Re: Written Comments Opposing SP-26-00010, Brown Road Estates II

Parcels 953834 & 428333 • 100 & 300 Anderville Lane, Ellensburg, WA

Applicant: Brown Road Estates, LLC

Zoning: Agriculture-5 • Land Use: Rural Residential

BROWN ROAD SHORT PLAT NO. 3  
PART OF SECTION 4, T. 17 N., R. 18 E., W.M.  
KITTITAS COUNTY, WASHINGTON

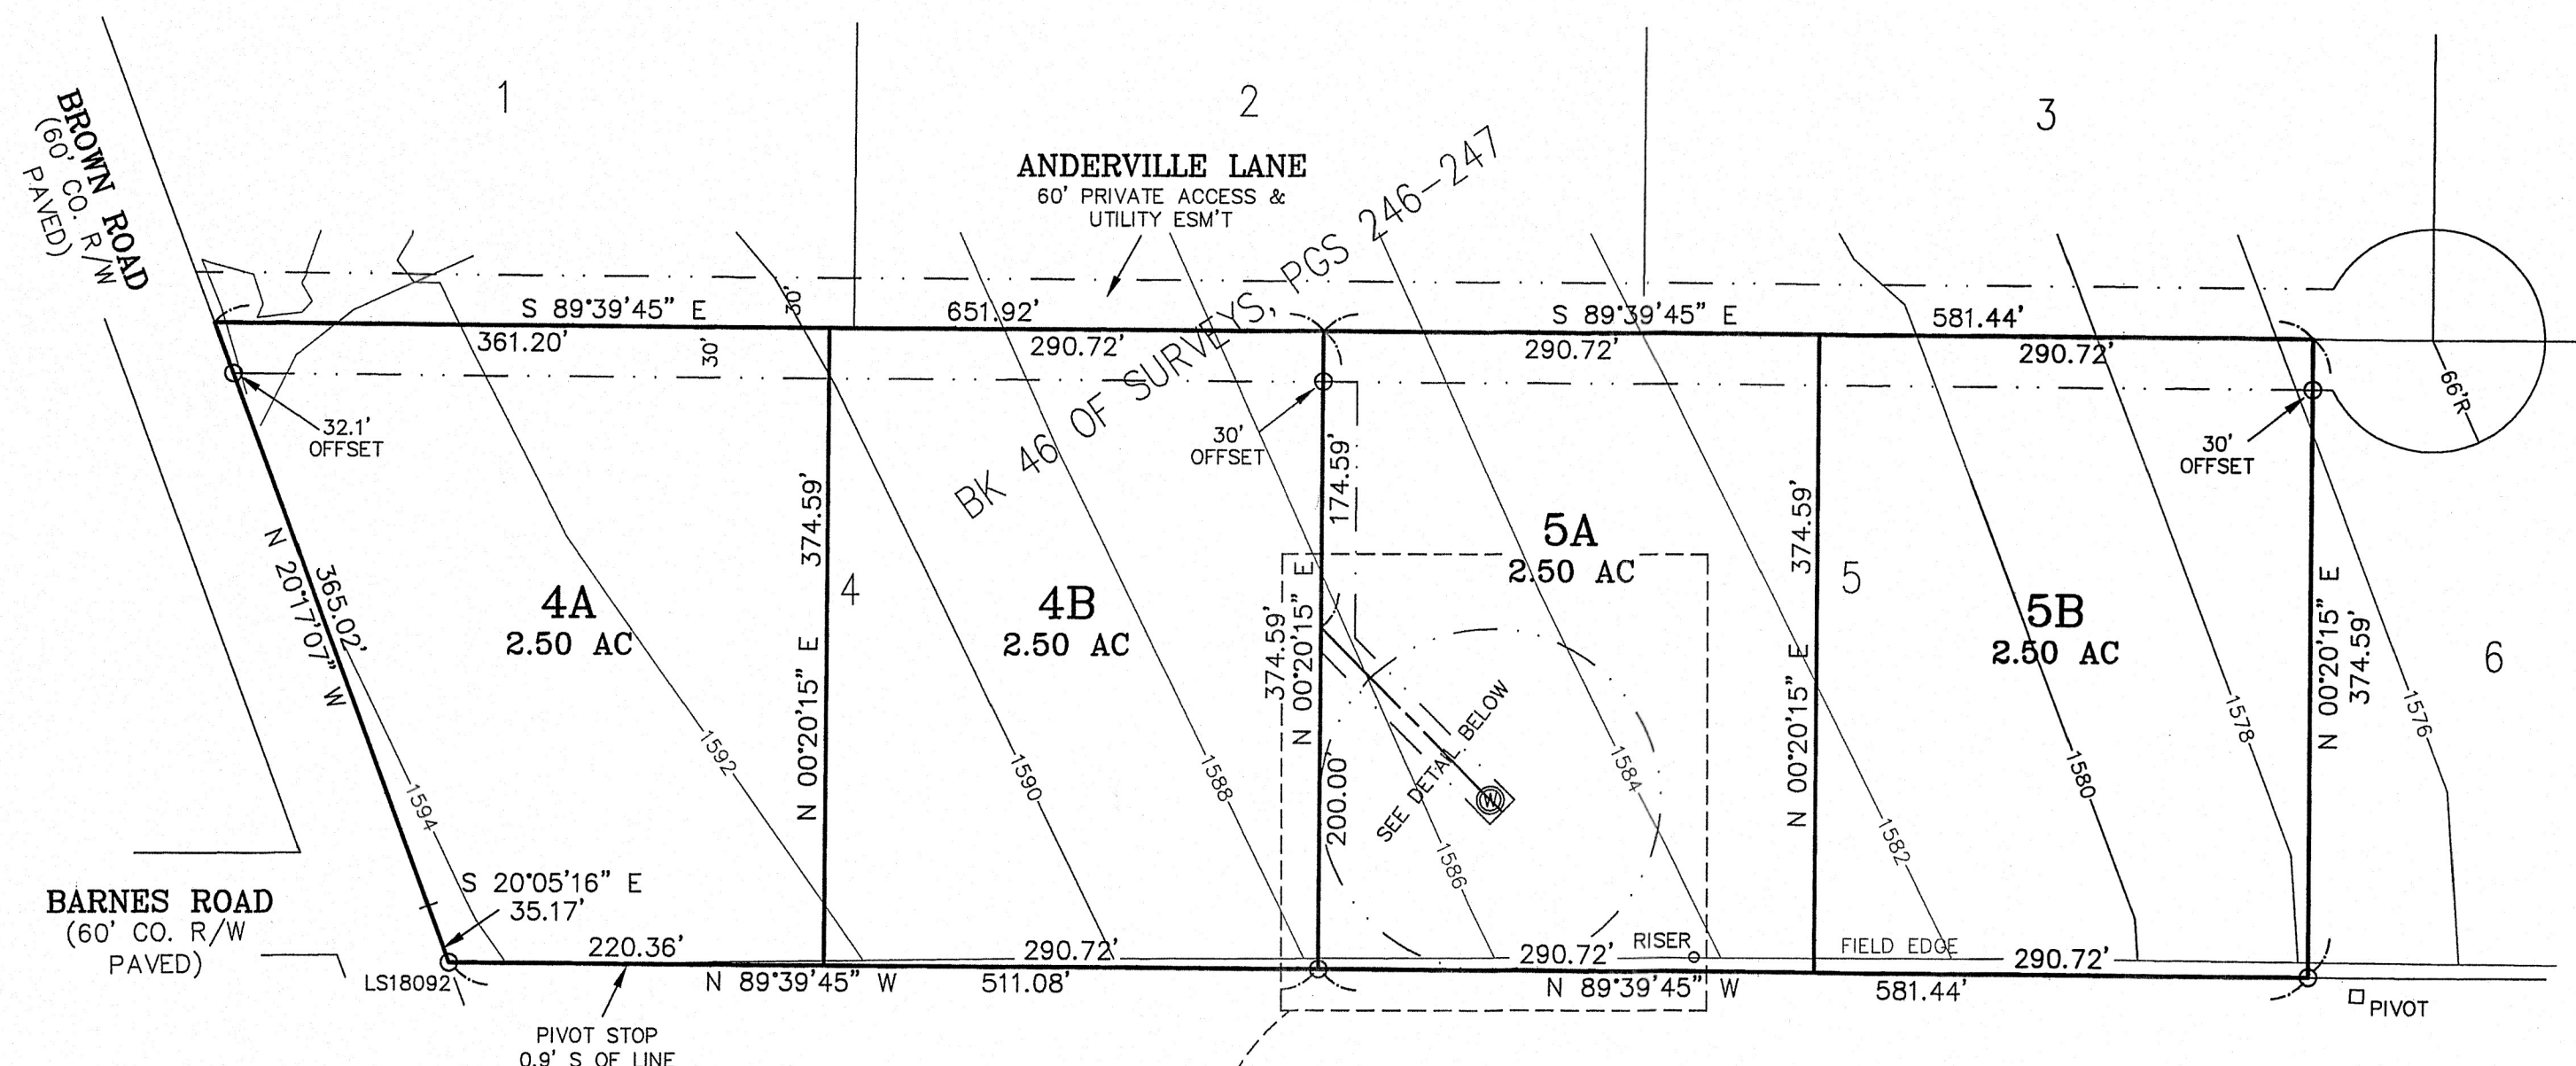
The applicant proposes four 2.5-acre lots on land zoned Agriculture-5 and states that TDR Density Credits in the form of TDR Certificates will be used “to meet the requirements of the density being requested to comply with zoning regulations.” That use of TDR is inconsistent with Washington State TDR policy, the Growth Management Act, and Kittitas County Code.

1. Agriculture-5 does not permit 2.5-acre lots.

The Agriculture-5 zone requires a five-acre minimum lot size. A short plat outside an urban growth area may create no more than four lots under KCC 16.08.186 and Chapter 16.32, but each lot must still meet the underlying zone. TDR credits are not a variance from minimum lot size and are not a rezone.

The only small-lot exception in KCC 16.12.040 is a single one-to-three-acre lot around an existing residence, subject to a covenant precluding further division while the land remains designated for agricultural use. That exception does not authorize four 2.5-acre lots across two parcels.

SP-26-00010 Brown Road Estates II Zoning

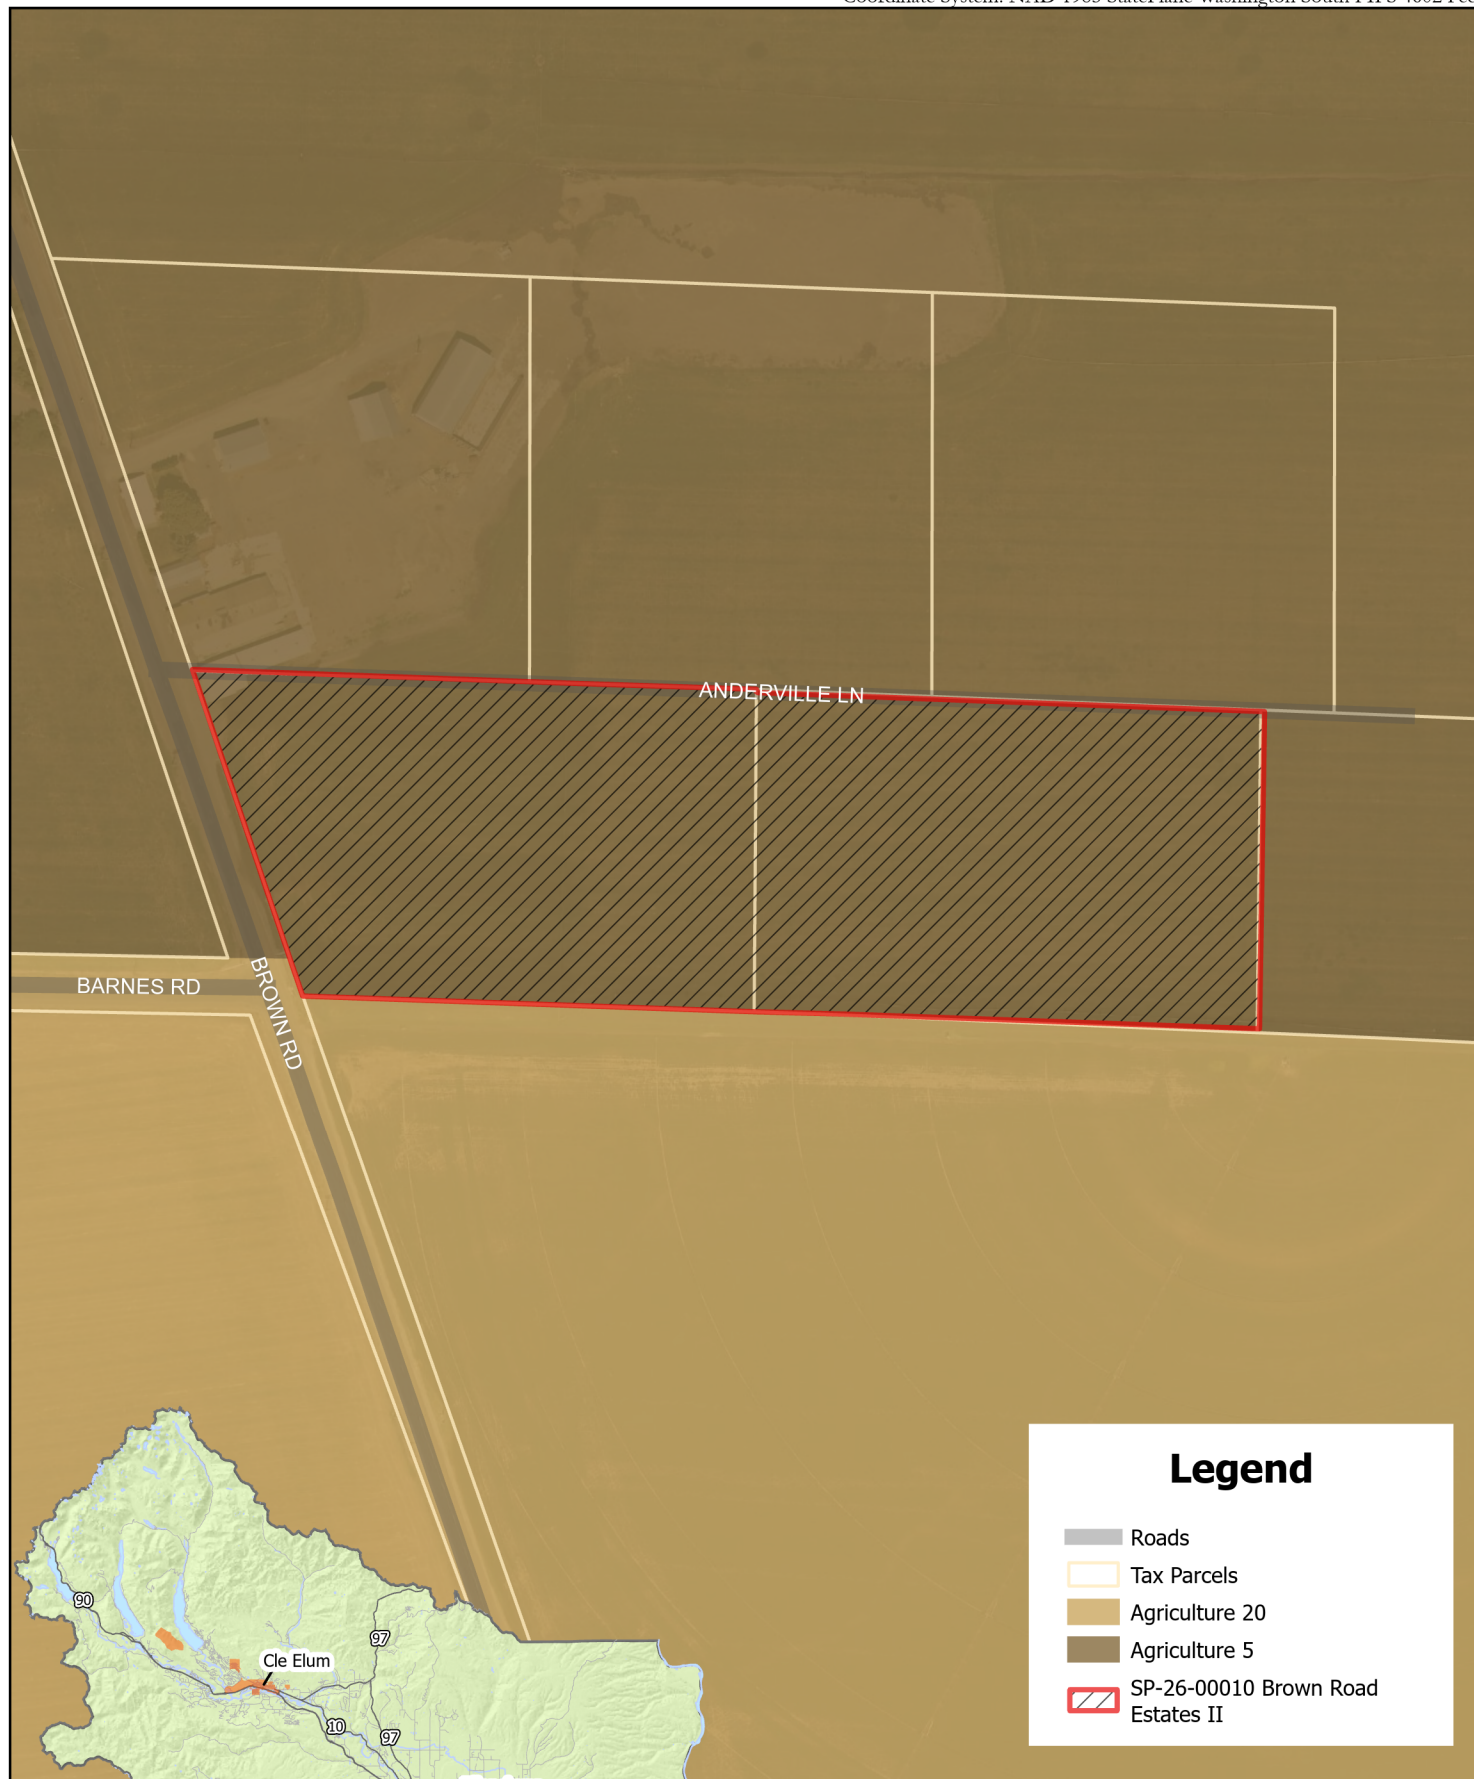
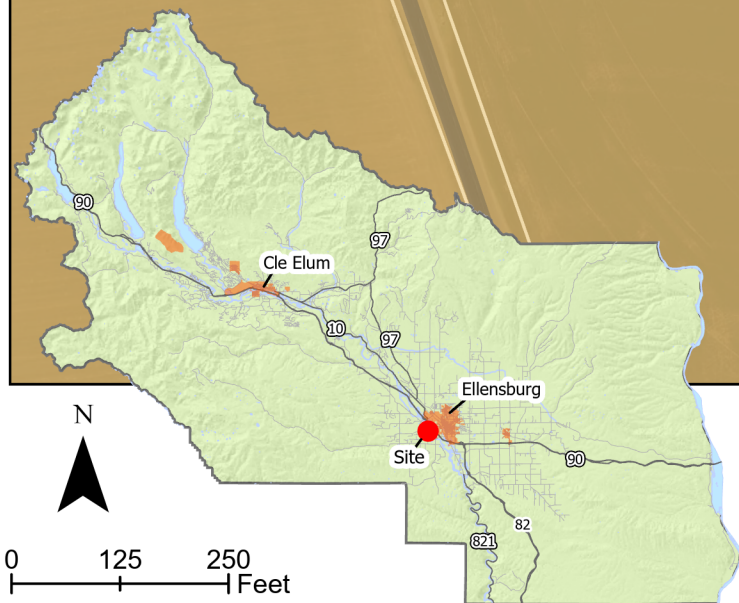
KCC Chapter 17.13 has the same purpose: permanently conserve rural farm and forest land by extinguishing development rights on designated sending sites and redeeming density credits on eligible receiving sites. Agriculture-5 land is a sending-site zone under KCC 17.13. Using TDR certificates to increase density on AG-5 land reverses the program. If the credits originated in an urban growth area, the transfer is even more contrary to GMA Goals 1, 2, and 8 in RCW 36.70A.020 (urban growth, reduction of sprawl, and conservation of natural resource industries).
